Report to be read in conjunction with the Decision Notice.

Application Ref:	3/2026/0042			 Ribble Valley Borough Council www.ribblevalley.gov.uk
Date Inspected:	03/03/26	Site Notice:	03/03/26	
Officer:	LW			
DELEGATED ITEM FILE REPORT:				REFUSAL

Development Description:	Outline application for the proposed erection of two dwellinghouses with access applied for.
Site Address/Location:	Land adjacent to Fernhill, Ribchester Road, Clayton le Dale,

PROPOSED SITE PLAN  
 (option 1)

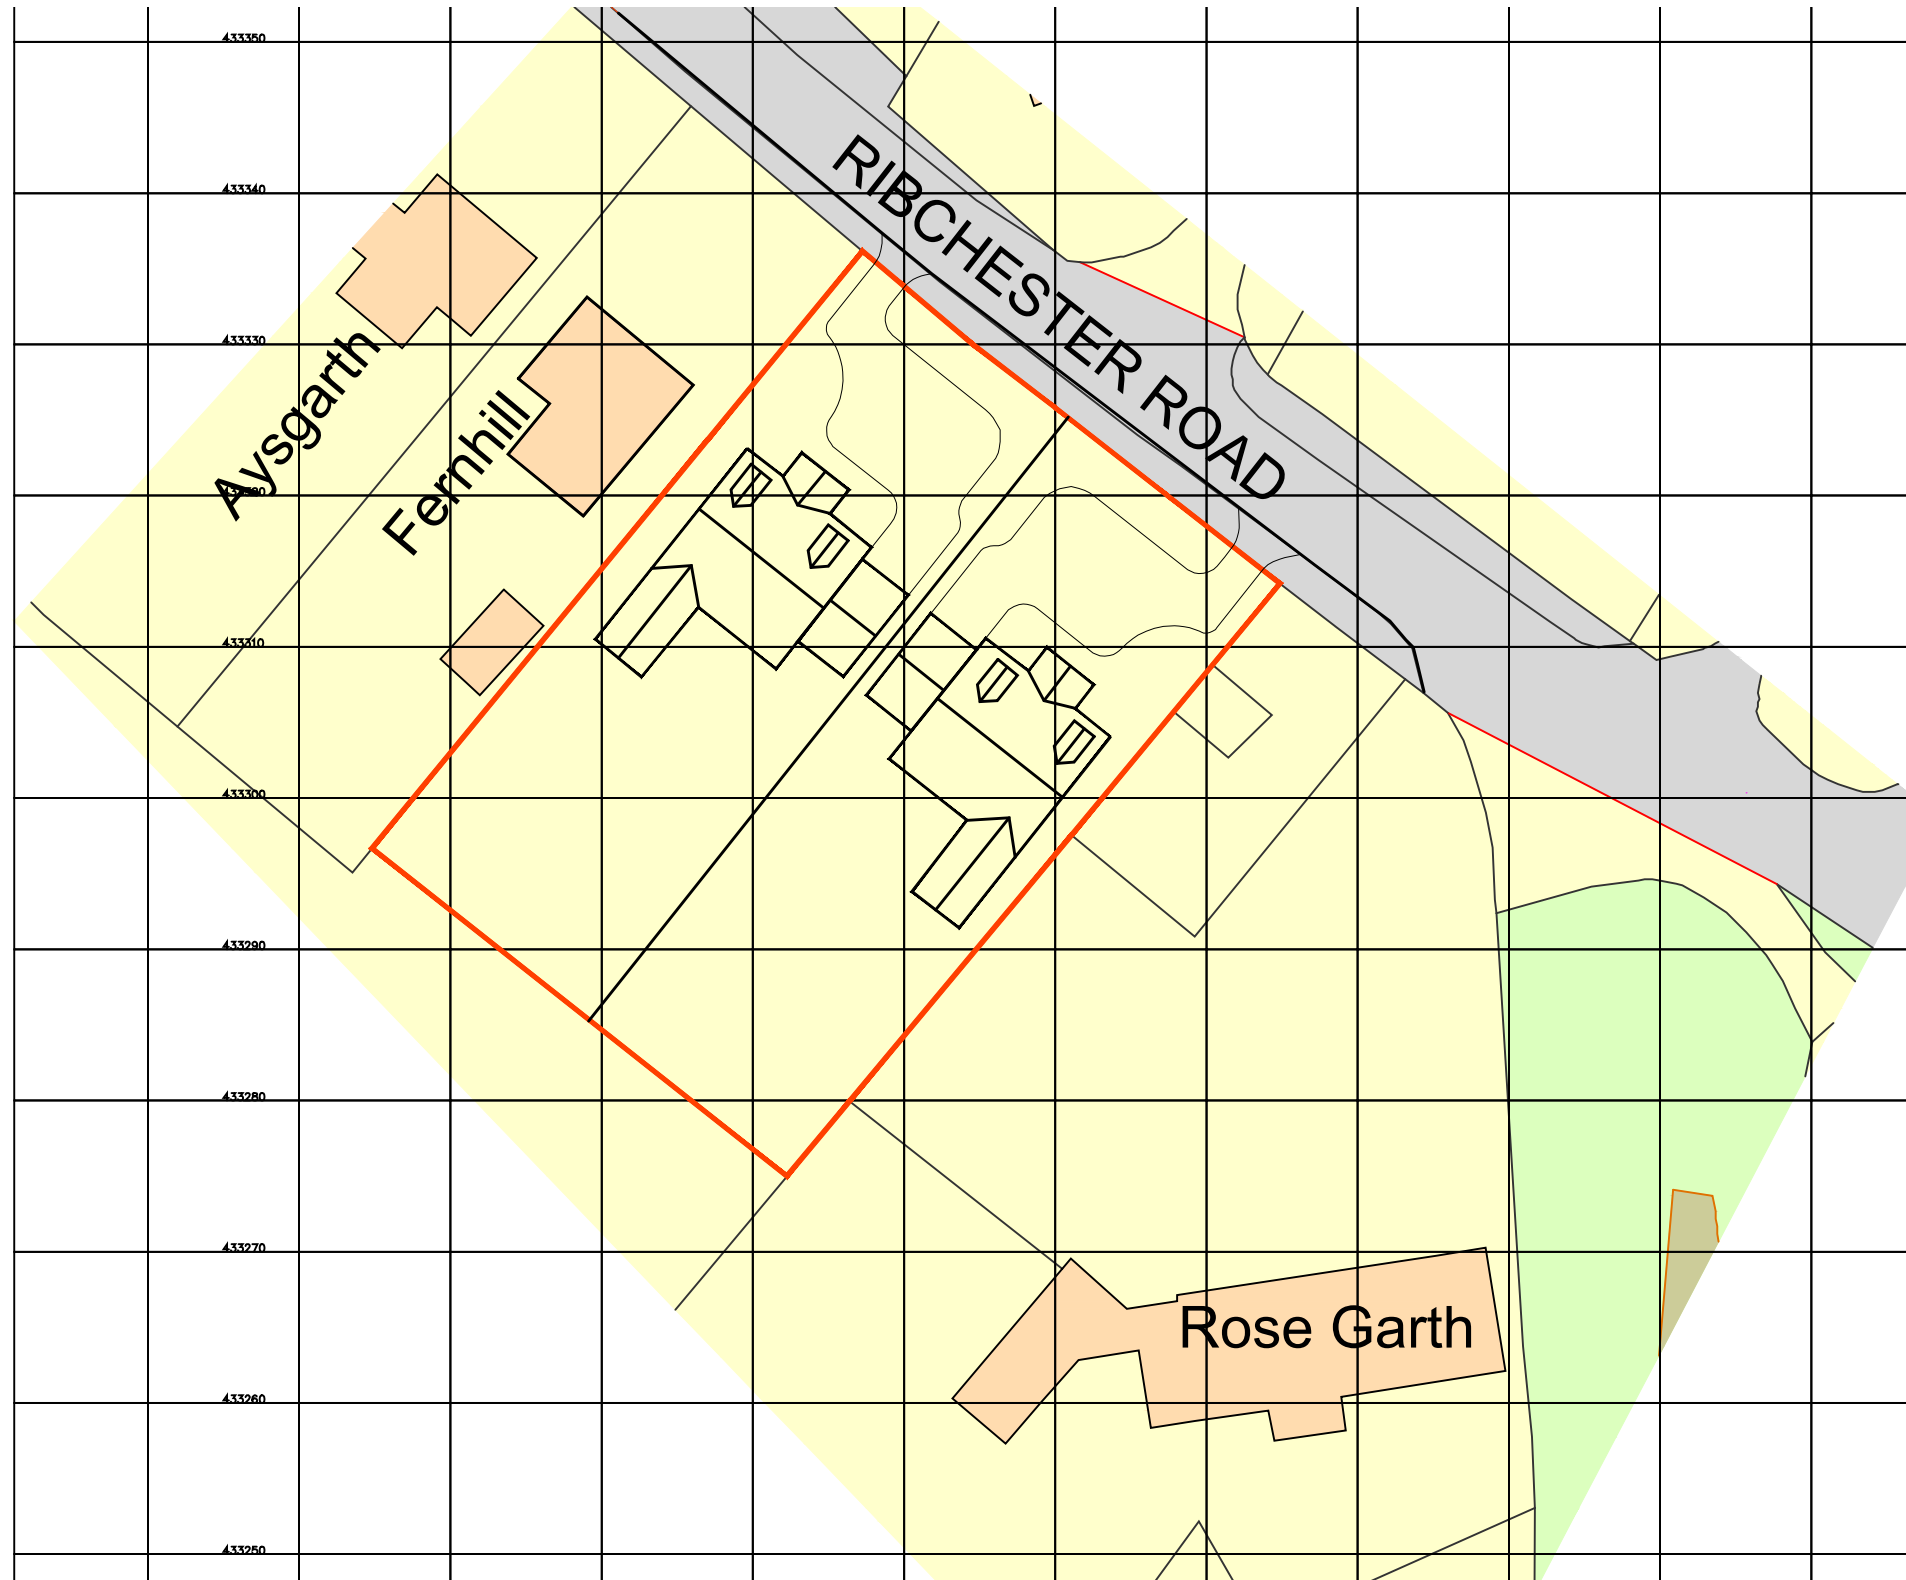
Two new vehicle access points are proposed from the site onto Ribchester Road. The Local Highway Authority (LHA) note that revised site plans are required based on measurements taken on site and not on the OS layer. The Proposed Site Plans submitted show a footway/ verge of up to 2m wide across the site frontage. The revised plans should show the correct width of the service verge, which is narrower, and locations of highway gullies and street lighting columns across the site frontage and immediately adjacent.

Furthermore, no site section plans have been submitted to demonstrate how appropriate access will be constructed given the level differences between the carriageway on Ribchester Road and the site, which slopes up from the road. The access should be constructed so that there is not a steep gradient to the driveways.

No visibility splay drawings have been submitted with the application. However, based on the above criteria, the LHA does not consider that adequate visibility splays could be achieved, with splays from both access points being over third-party land. Unless and until adequate visibility splays have been

demonstrated from the site, which may require the access points being re-located, the LHA objects to the application.

The accesses would also need to be surfaced in bound material for at least 5m into the site from the back edge of the service verge and surface water collected across the front of the accesses and drained to suitable internal outfalls to prevent surface water from discharging into the public highway network. This could be secured via an appropriately worded planning condition.

The construction of the access would need to be carried out under a legal agreement (Section 278) with the LHA. Works should include, but not be exclusive to, the construction of the accesses to an appropriate standard, the relocation of any highway gullies out of the access points onto Ribchester Road and a street lighting assessment.

Traffic may be travelling below the maximum speed limit, and shorter visibility splays may be accepted. However, these would need to be supported through data obtained by an automated seven-day survey carried out in a neutral month, avoiding school holidays, national holidays and events, or local events which could impact on traffic movements and with prevailing weather conditions noted.
